4 December 2018

Our Ref: R/2014/39/J  
File No: 2018/600170  
Your Ref: SSD 7484 MOD 3

**Modification Application – The Sandstone Precinct – SSD 7484 (MOD 3), 23-33 & 33-35 Bridge Street, Sydney**

EDUCATION BUILDING - WEST

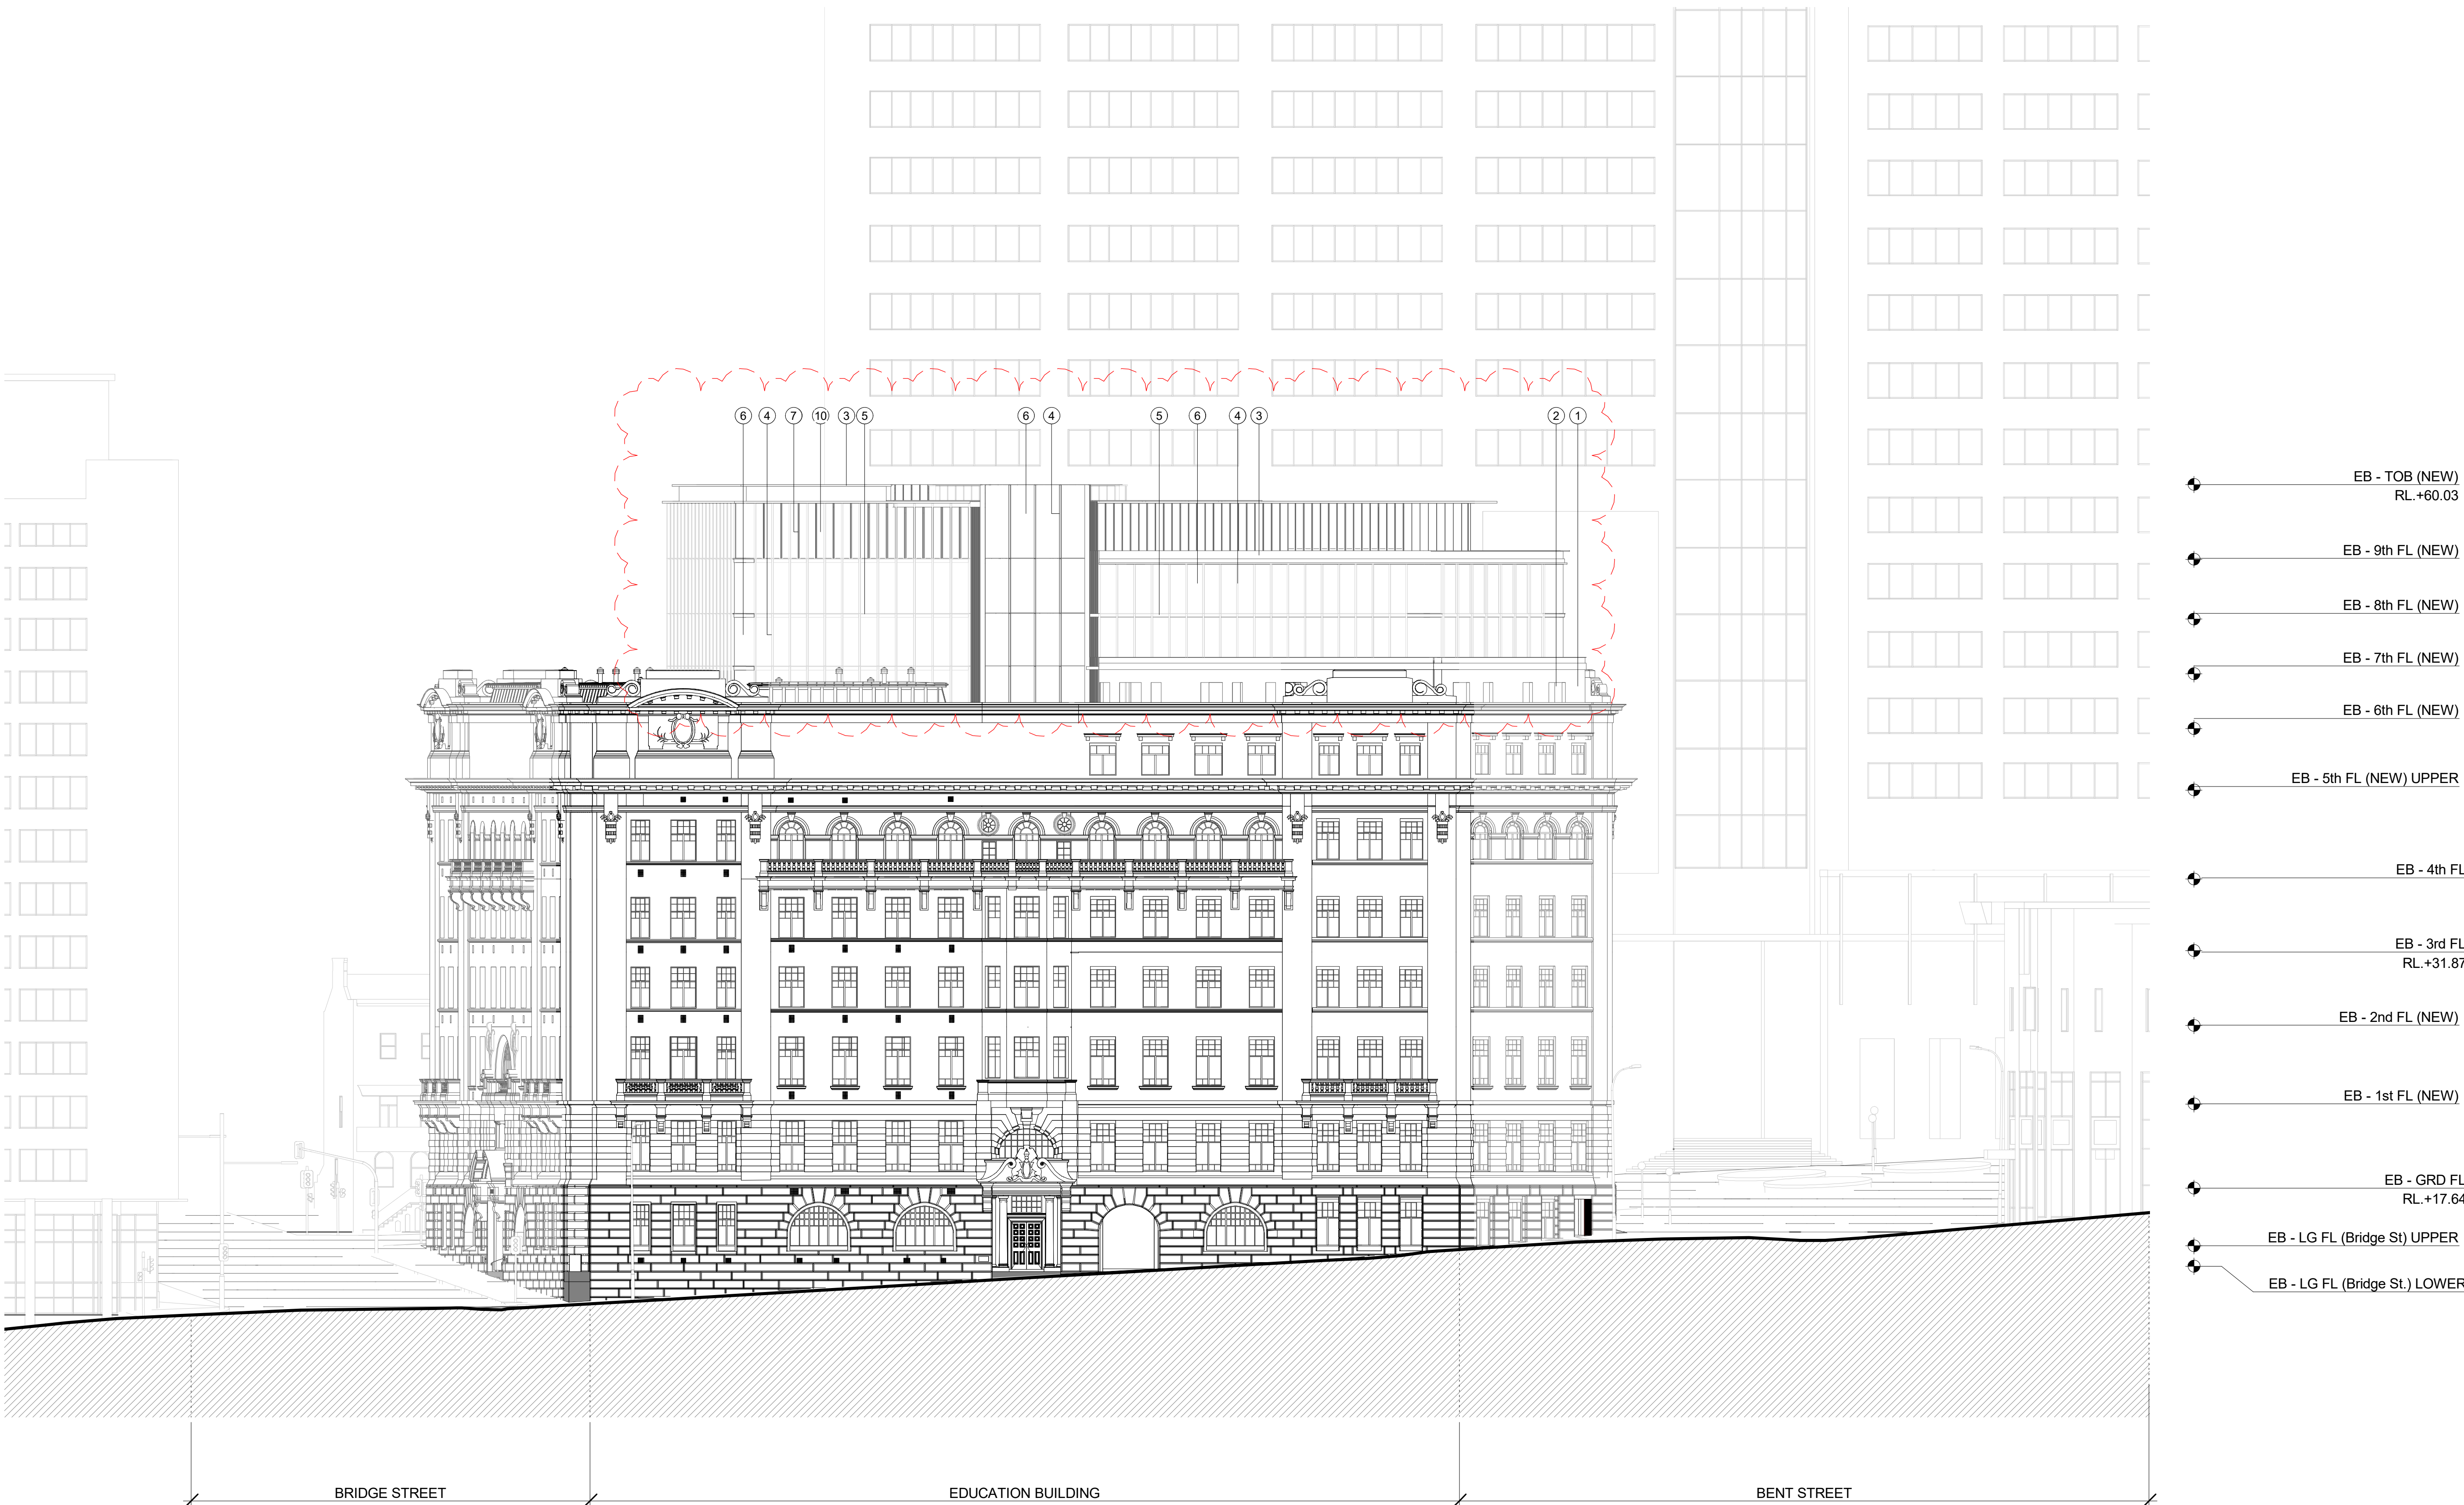
The blocking of three existing window on the west elevation at ground level to accommodate public toilets is **not supported**. These windows are on the primary west elevation. They are not shown blocked in the approved design. Blocking them is neither necessary nor desirable and has a negative heritage impact. Due to the street gradient, these windows are at first floor level so the privacy requirements for the toilets would be better served by applying obscuring film to the glass and allowing the windows to naturally light the toilets. The approved design is a preferable heritage and ESD outcome and this modification is **not supported**. The layout of these toilets can be readily amended to optimise the internal presentation of the conserved and exposed windows.

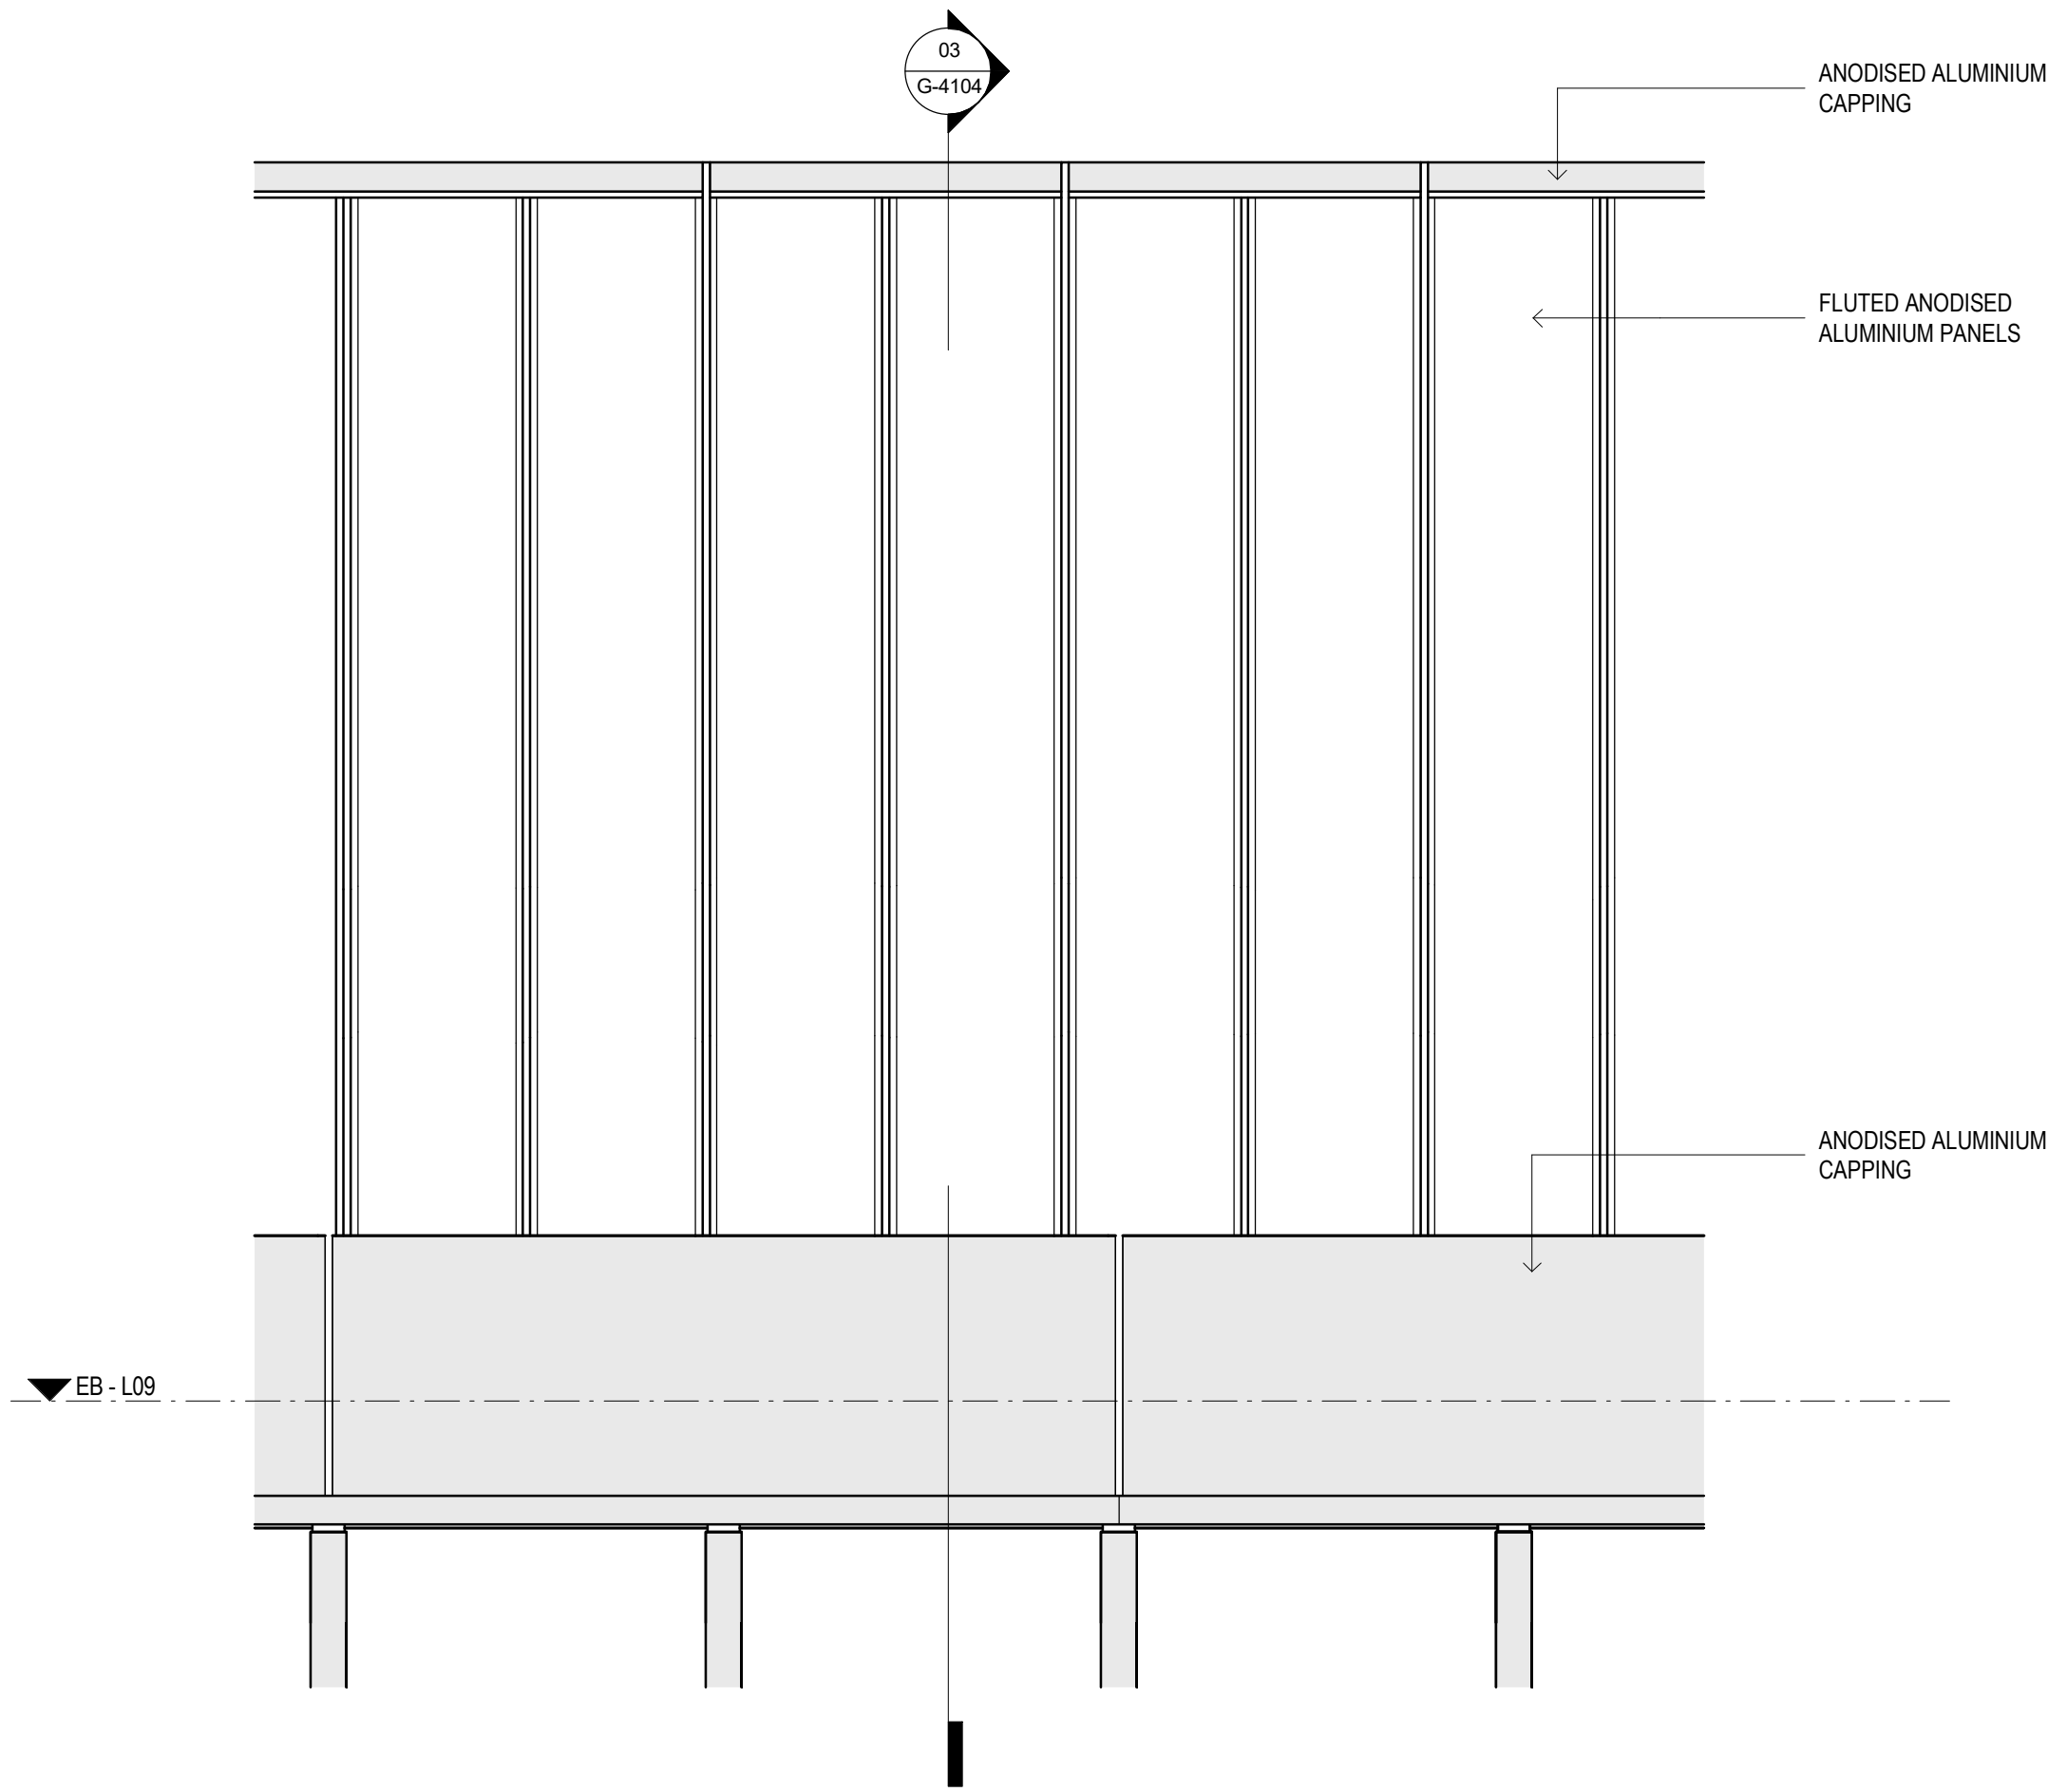
The proposed sandstone toned fluted reconstituted stone cladding to the new lift/vertical services shafts on the east and west sides of the building extension (shown on elevations and detailed on drawing SP-DA-G-4103/02 and *Extending the Sandstone Bays* in the Design Report) is **not supported** for the following reasons:

- The Sandstone precinct (Lands/Education/Secretary General) is distinguished by strong sandstone street walls. Above this datum are metal-clad roofing elements (mainly copper clad). The only exception to this is the landmark tower of the existing

Lands Department building. The extension to the Education buildings is intended to be recessive and is not to compete with the landmark status of the existing Lands Department Tower. It should therefore be clad in metal to be clearly identified with the roof zone of the sandstones precinct. The proposed masonry cladding to these above-parapet elements on the east and west sides of the extension will not weather or oxidise in a manner consistent with Sydney sandstone and will add to the visual intrusion of the additional floors. They will make the extension less recessive and it will visually compete with the tower on the Lands Department building. It is recommended that the sandstone toned fluted reconstituted stone cladding be replaced with fluted copper cladding. This could be manufactured in panels similar in scale and profile to the reconstituted masonry panels shown in the current designs. The metal is recommended to be copper (to relate to the existing roofs of the precinct). This will initially harmonise with the selected bronze curtain wall system but will eventually oxidise to a lighter natural verdigris finish. A pre-finished zinc, as used at Governor Phillip Tower/Museum of Sydney, may also be potentially acceptable.

- The reasoning for *Extending the Sandstone Bays* in the Design Report is **not supported**. It justifies the form of the proposed elements, but not the material. The introduction of a novel material - reconstituted stone - into the existing characteristic palette of materials in the Sandstones Precinct – sandstone, copper, painted metal – is likely to conflict with the existing building and the precinct. As stated above, it is not considered that stone or masonry cladding is appropriate for these elements. Governor Phillip Tower provides the precedent. All materials above the datum of the Museum of Sydney sandstone wall is metal or glass. The proposed reconstituted stone cladding is considered to be inconsistent with CMP policy 6.11.6 as it is not a *superior construction material that [is] sympathetic to the significance and appearance of the historic building and its significant views* (p10 of HIS).
